Rezoning Transportation Analysis

Petition Number: #2022-031

From: Jake Carpenter, PE

RZ-1

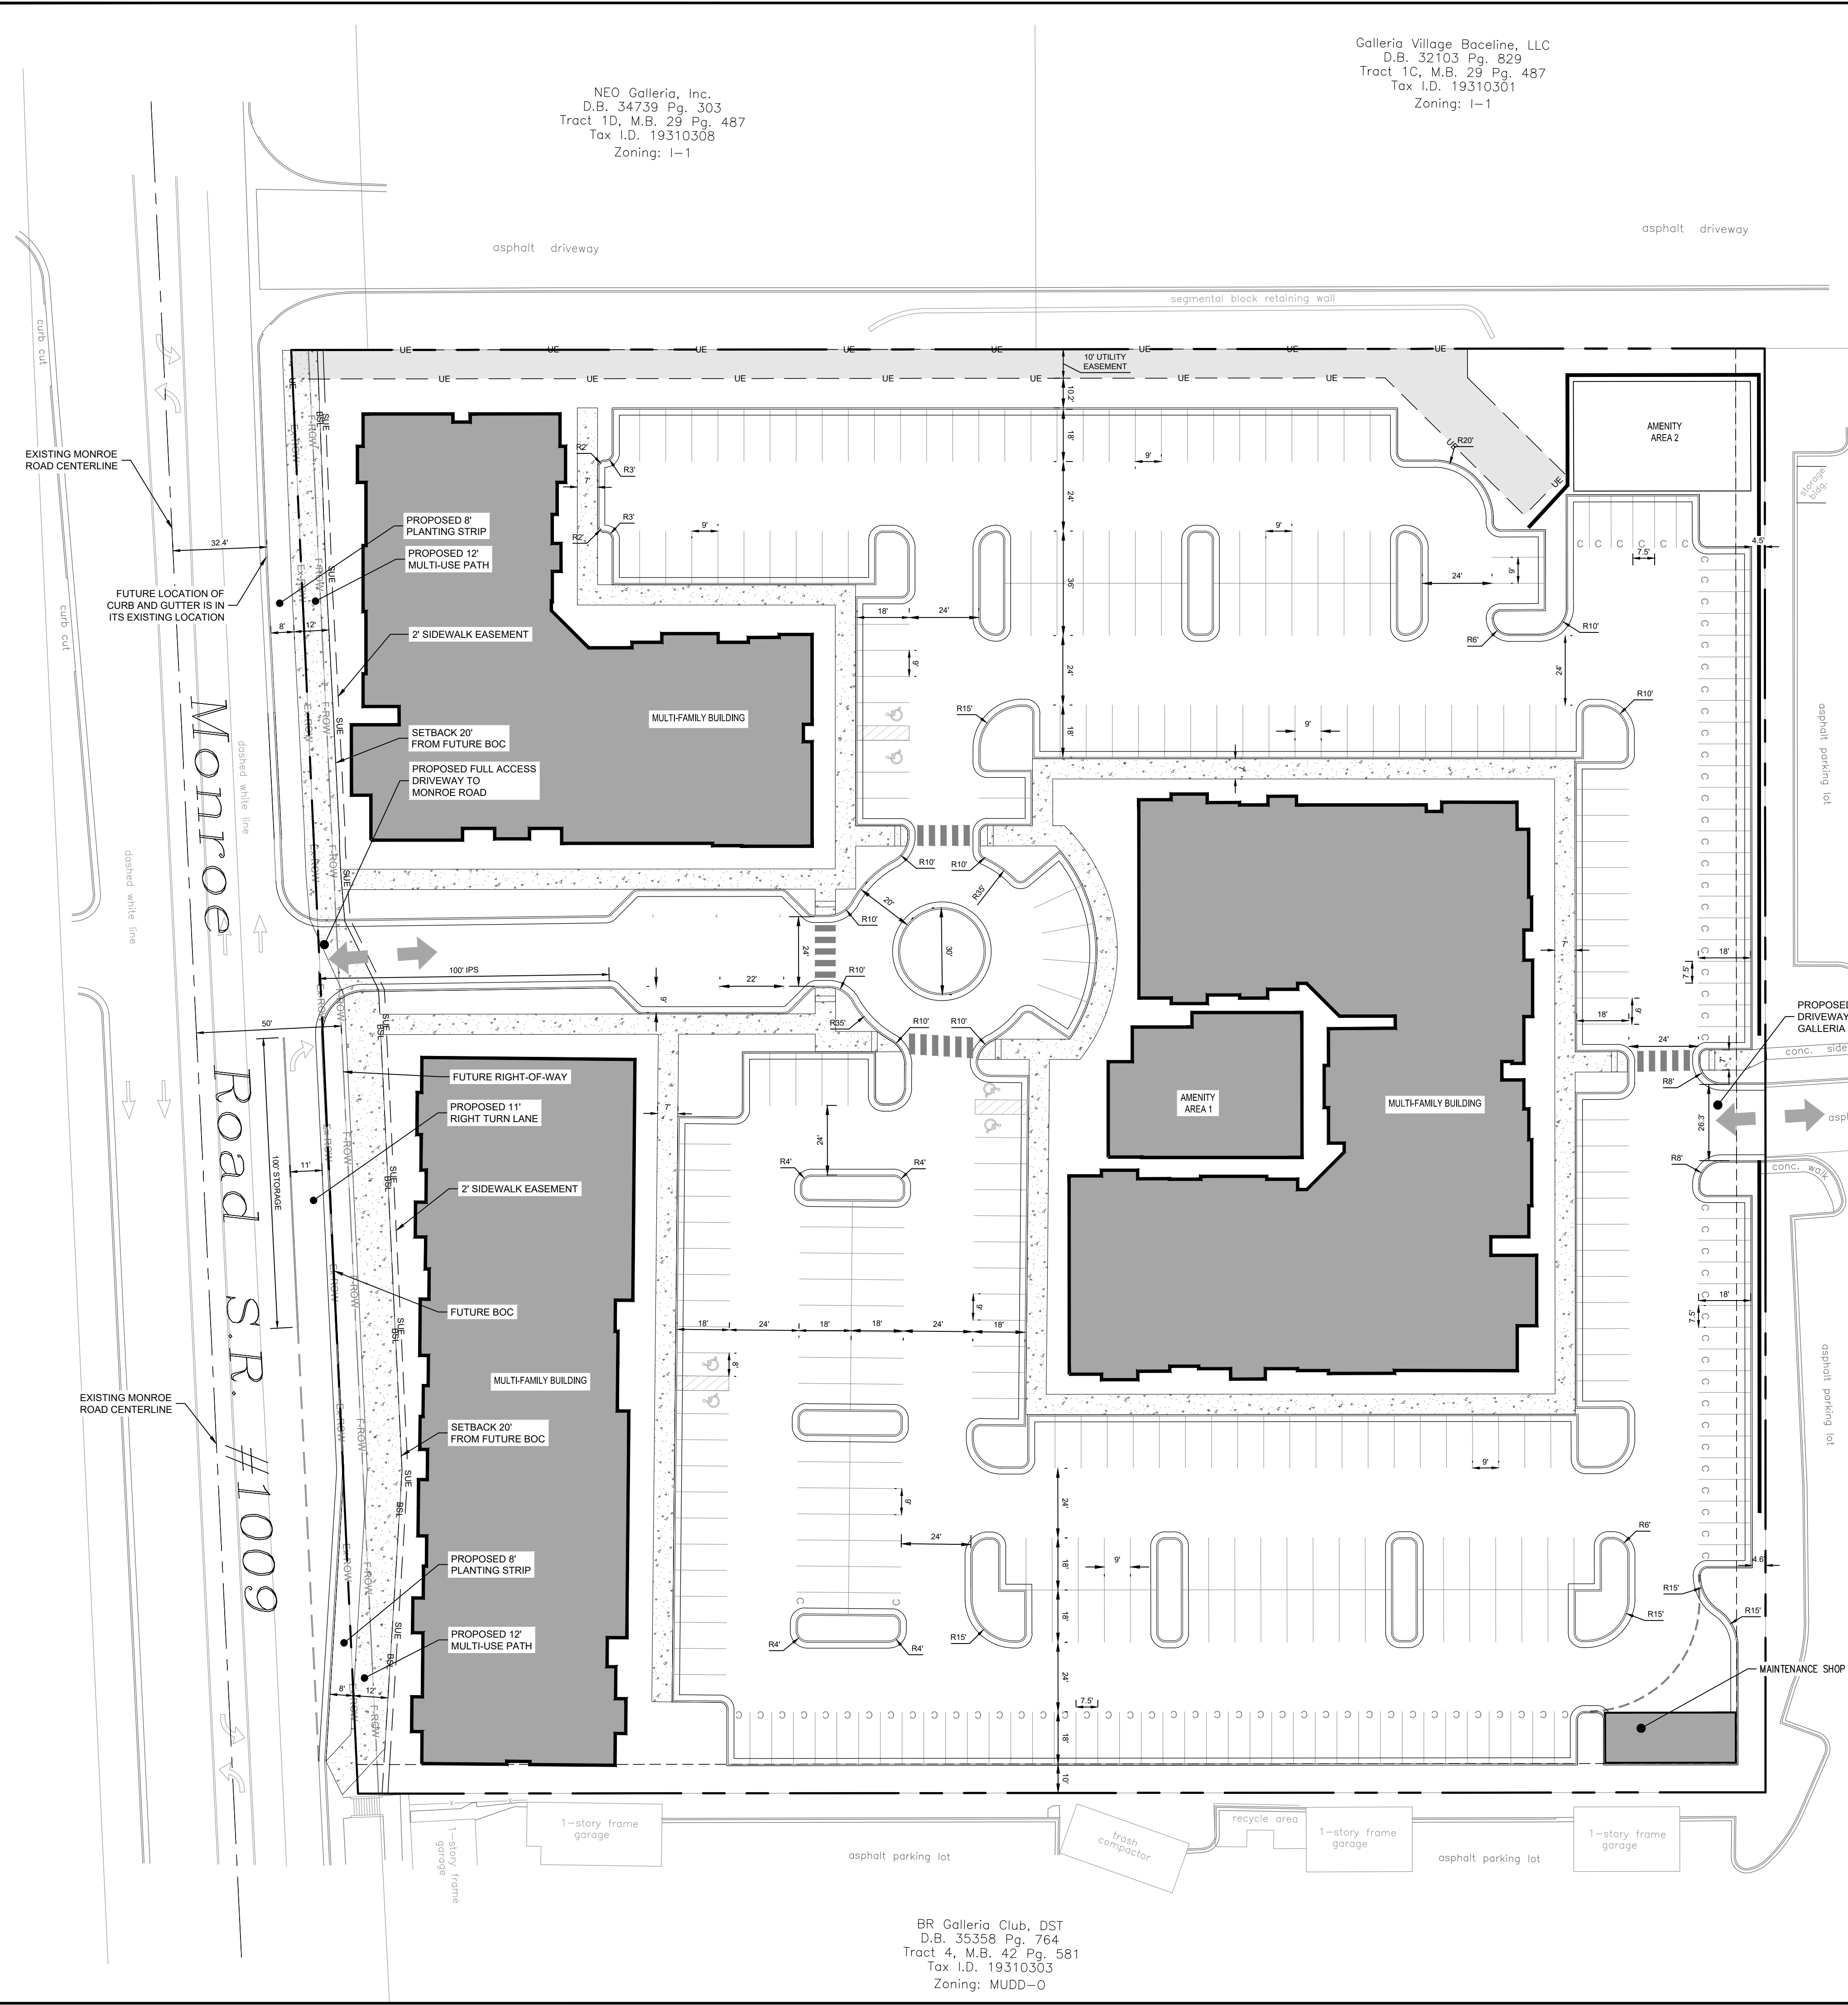
5. **CDOT REQUEST:** Revise site plan and conditional note(s) to provide a private street connecting Galleria Club Lane to Monroe Road. Comment Rescinded 8-26-22

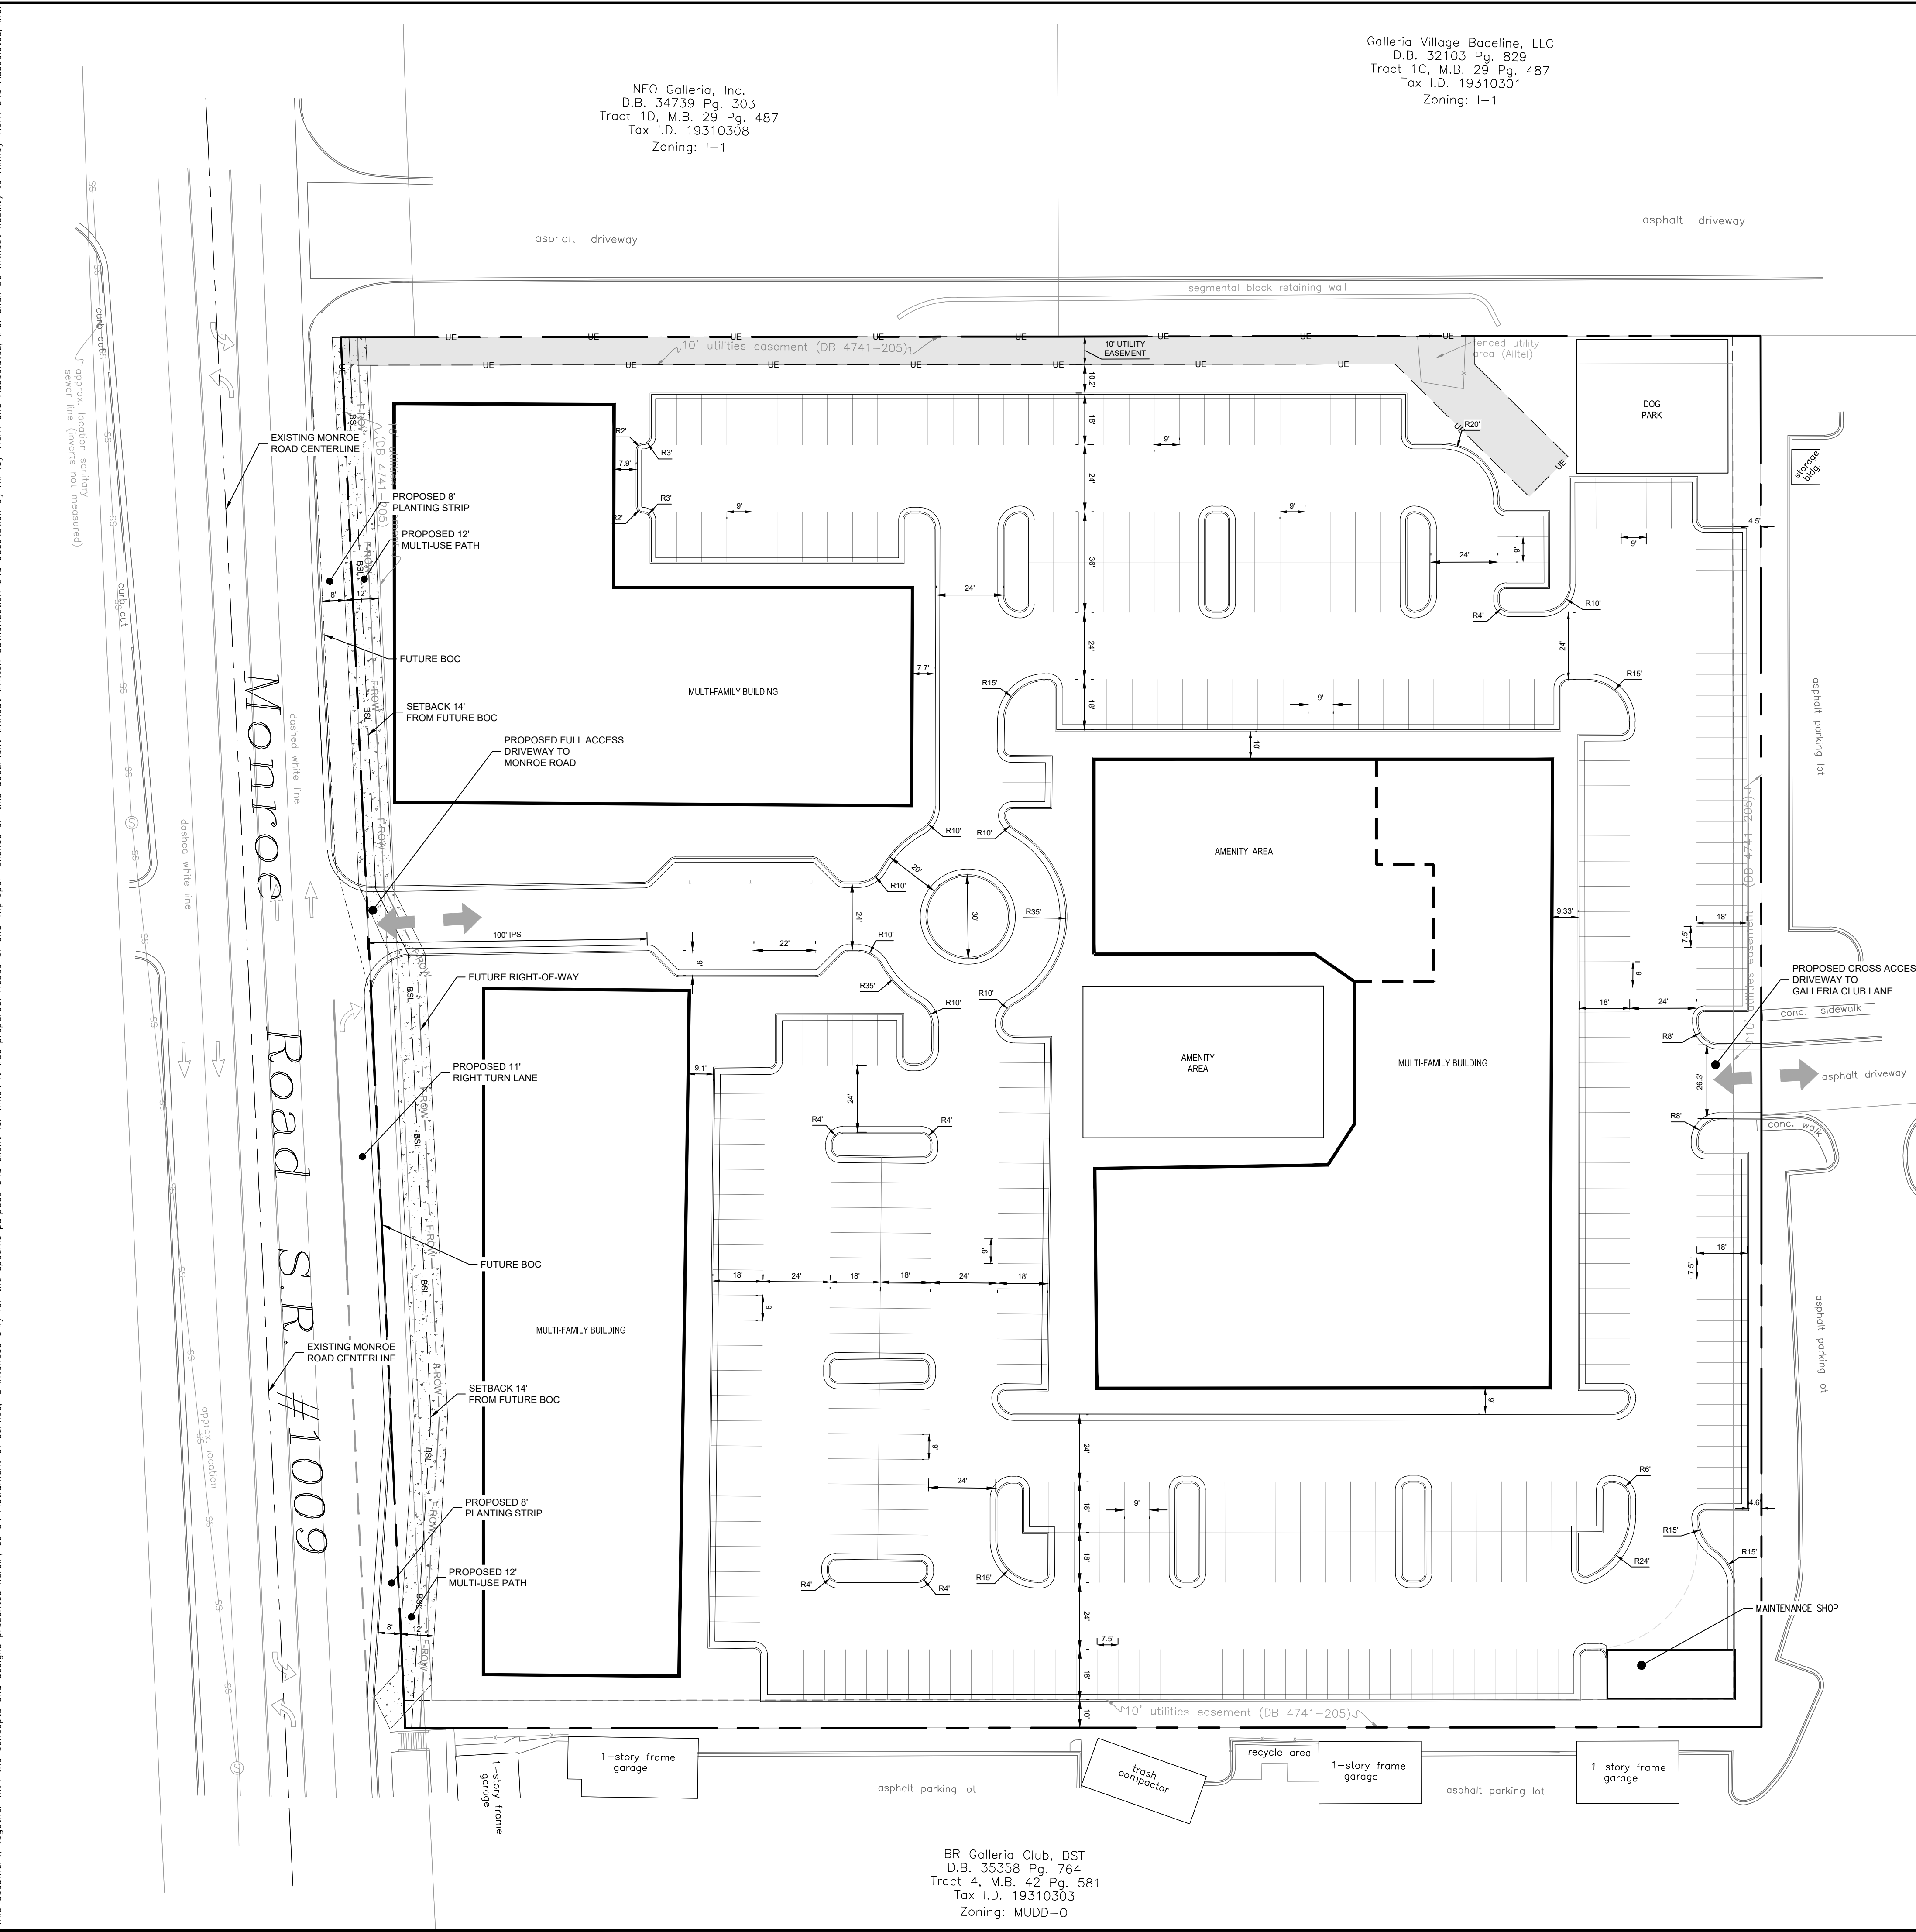
1. ~~**Curbline:** The proposed zoning district has a setback measured from back of the existing or proposed future curbline.~~
 - a. ~~**Monroe Road:** The future location of curb and gutter is in its existing location.~~

~~Label and dimension the curb and gutter from the centerline for each road on the site plan.~~
2. **Traffic Study:**
A Traffic Impact Study (TIS) is not necessary for the complete review of this petition due to the site generating less than 2,500 daily trips. If during the permitting process the site generates more than 2,500 daily trips, then a traffic study will be required.

3. ~~Site plan and conditional note(s) revisions are needed to provide a minimum of 100-foot of protected internal driveway stem at the proposed site access. The protected stem length should be dimensioned from the right of way on Monroe Road.~~

4. ~~Site plan and conditional note(s) revisions are needed to commit to installing a right turn lane on Monroe Road with a minimum of 100-foot of storage per NCDOT coordination. Label and dimension right turn lane on site plan and add conditional note describing all turn lane design requirements.~~

- ~~6. A site plan note(s) specifying dedication and fee simple conveyance of all rights-of-way to the City before the site's first building certificate of occupancy is issued as needed. CDOT requests rights-of-way set at 2' behind back of sidewalk where feasible.~~

- ~~7. Site plan revisions are needed to provide sidewalk utility easement or ROW located 2-feet behind the 12-foot MUP on Monroe Road. Identify the SUE on the site plan.~~
